**Town of Addison
Summary of Engineering Revision Comments**

Development: Galaxy FBO

Town Project #:19-09D

Town of Addison Engineering Review Conditional Civil Approval

SHEET NUMBER
C04.01

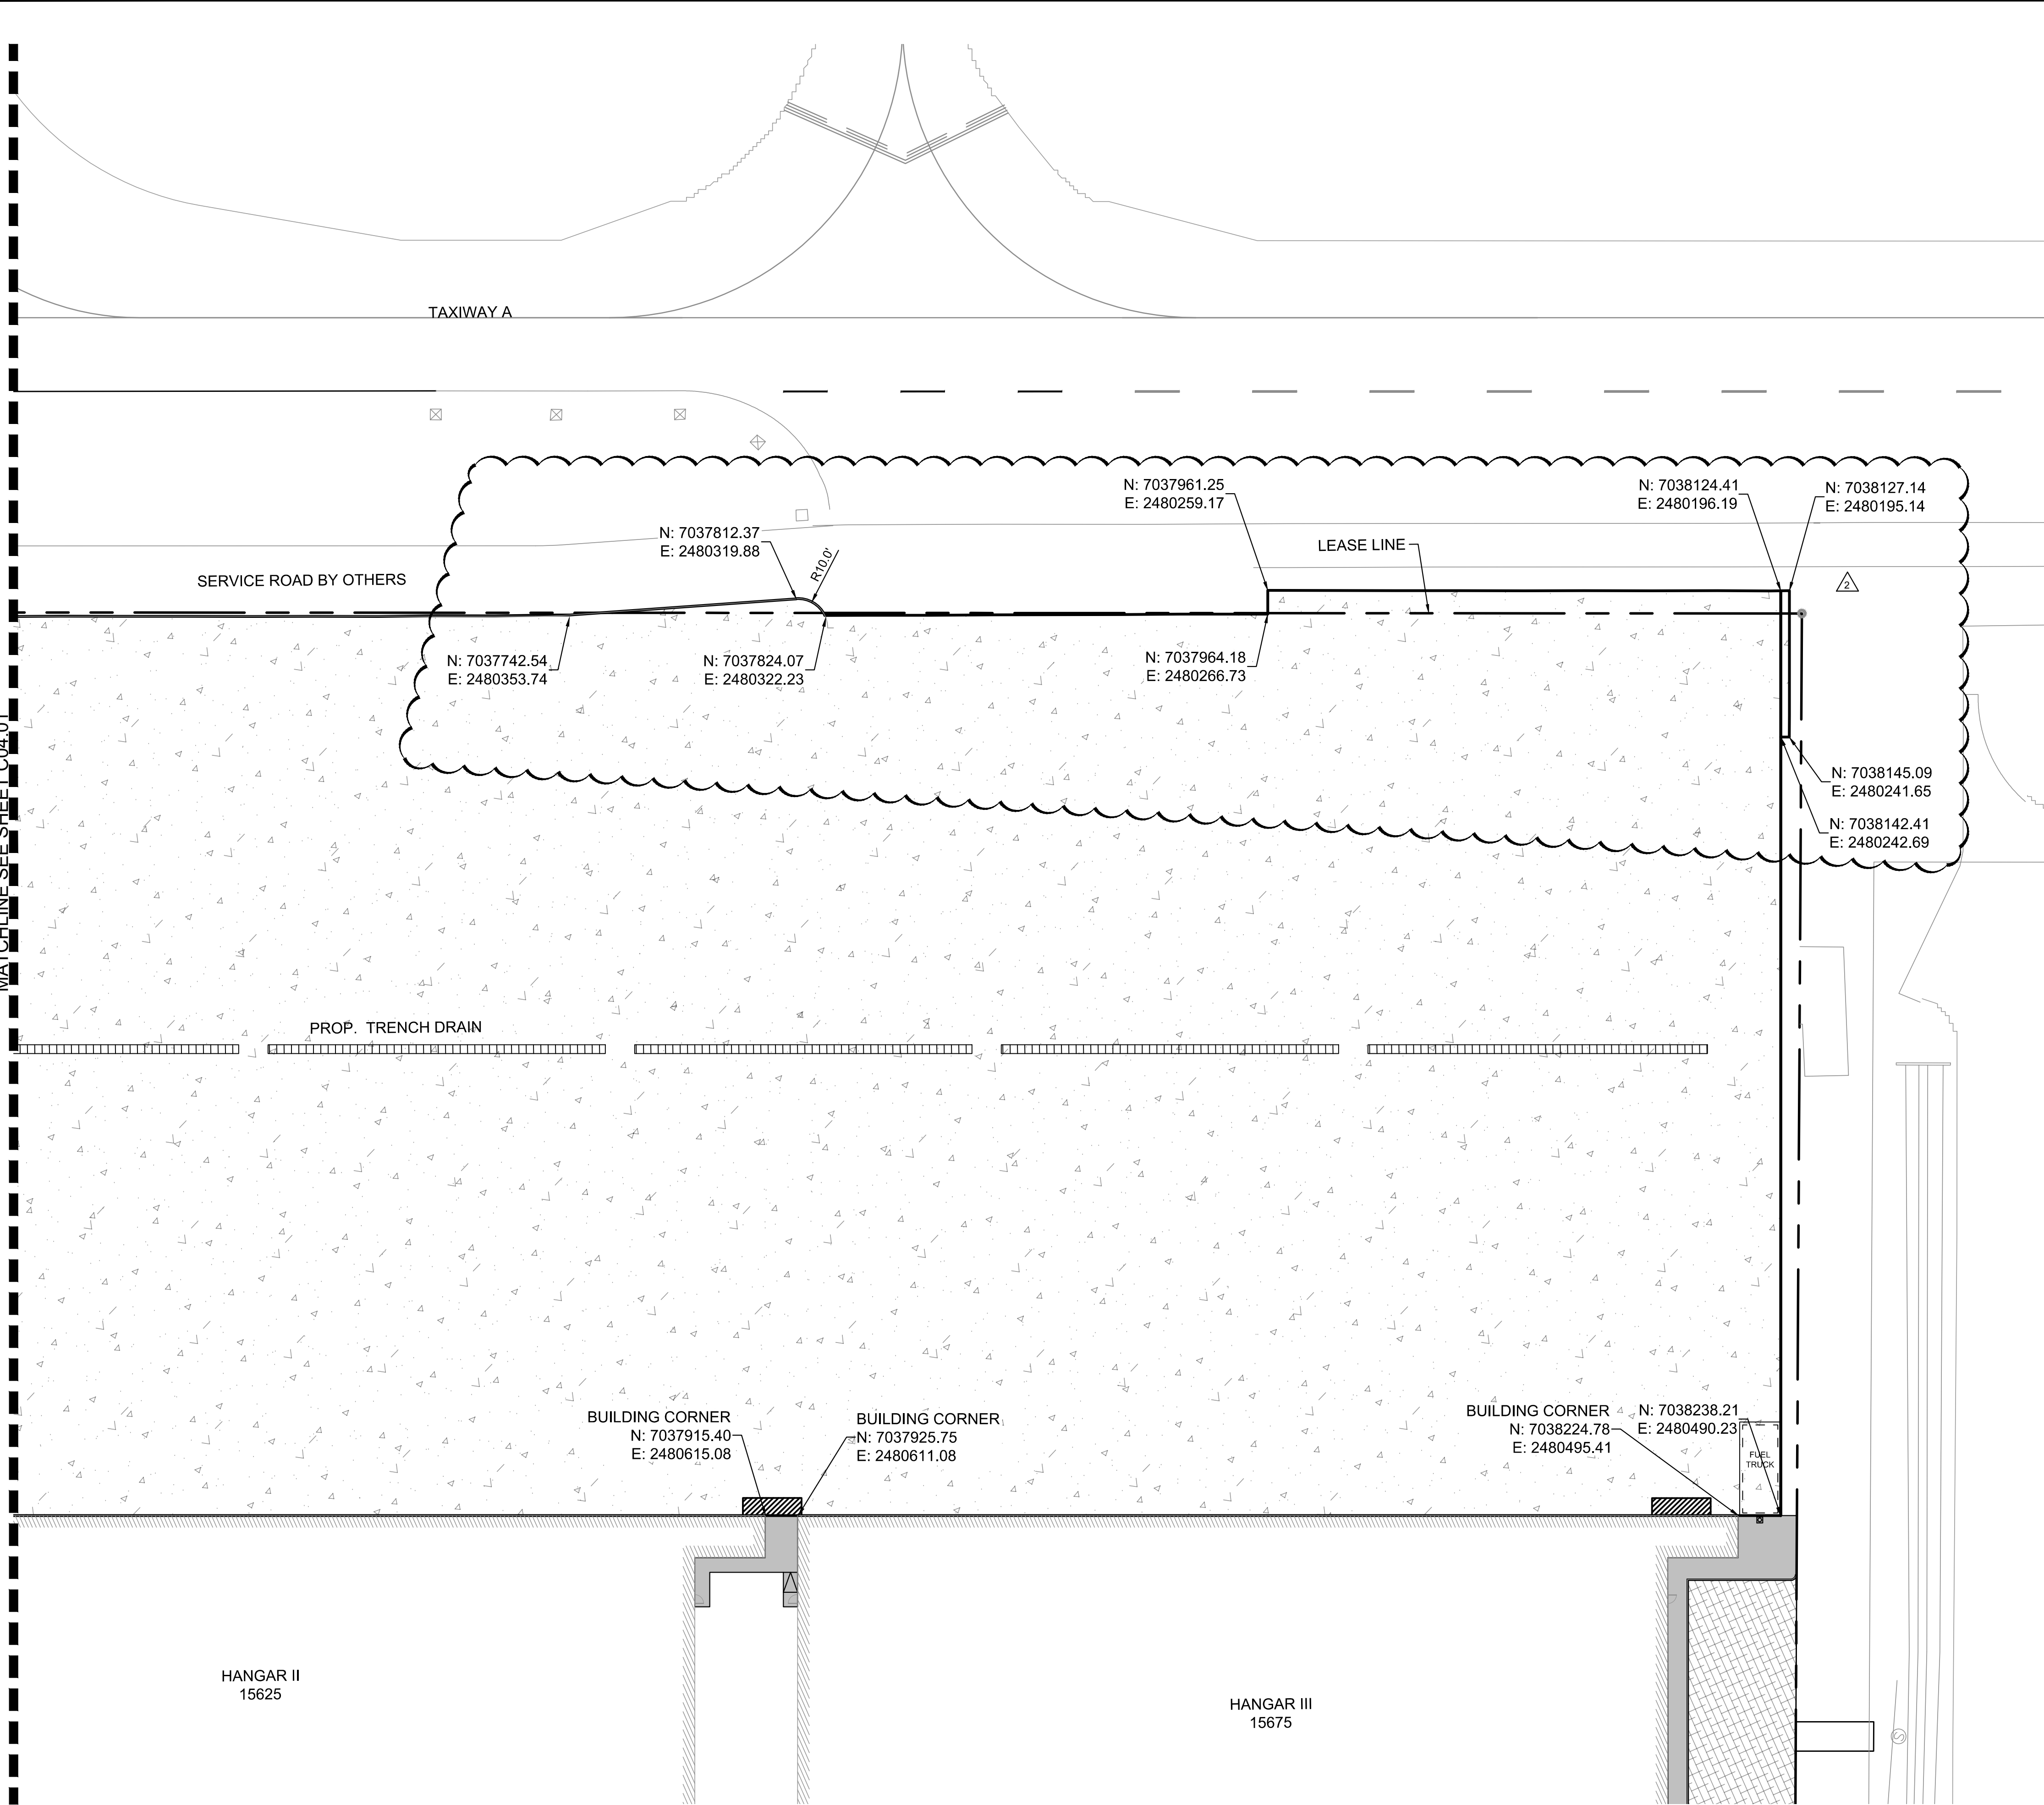
Revision No.	Date	Page No.	Comments	Reason for changes
ASI-C006	10/30/2020	C03.02	Updated the demo limits along the edge of the perimeter road per field conditions verified by a construction progress topographic survey.	
ASI-C006	10/30/2020	C04.01	Updated apron layout/geometry per field conditions verified by a construction progress topographic survey.	
ASI-C006	10/30/2020	C04.02	Updated apron layout/geometry per field conditions verified by a construction progress topographic survey.	
ASI-C006	10/30/2020	C05.01	Updated door locations on Hangar 1 to coordinate with revised architectural plans.	
ASI-C006	10/30/2020	C05.03	Updated door locations on Hangar 3 to coordinate with revised architectural plans.	
ASI-C006	10/30/2020	C06.01	Updated joint layout based on the minor apron layout/geometry changes.	
ASI-C006	10/30/2020	C06.02	Updated joint layout based on the minor apron layout/geometry changes.
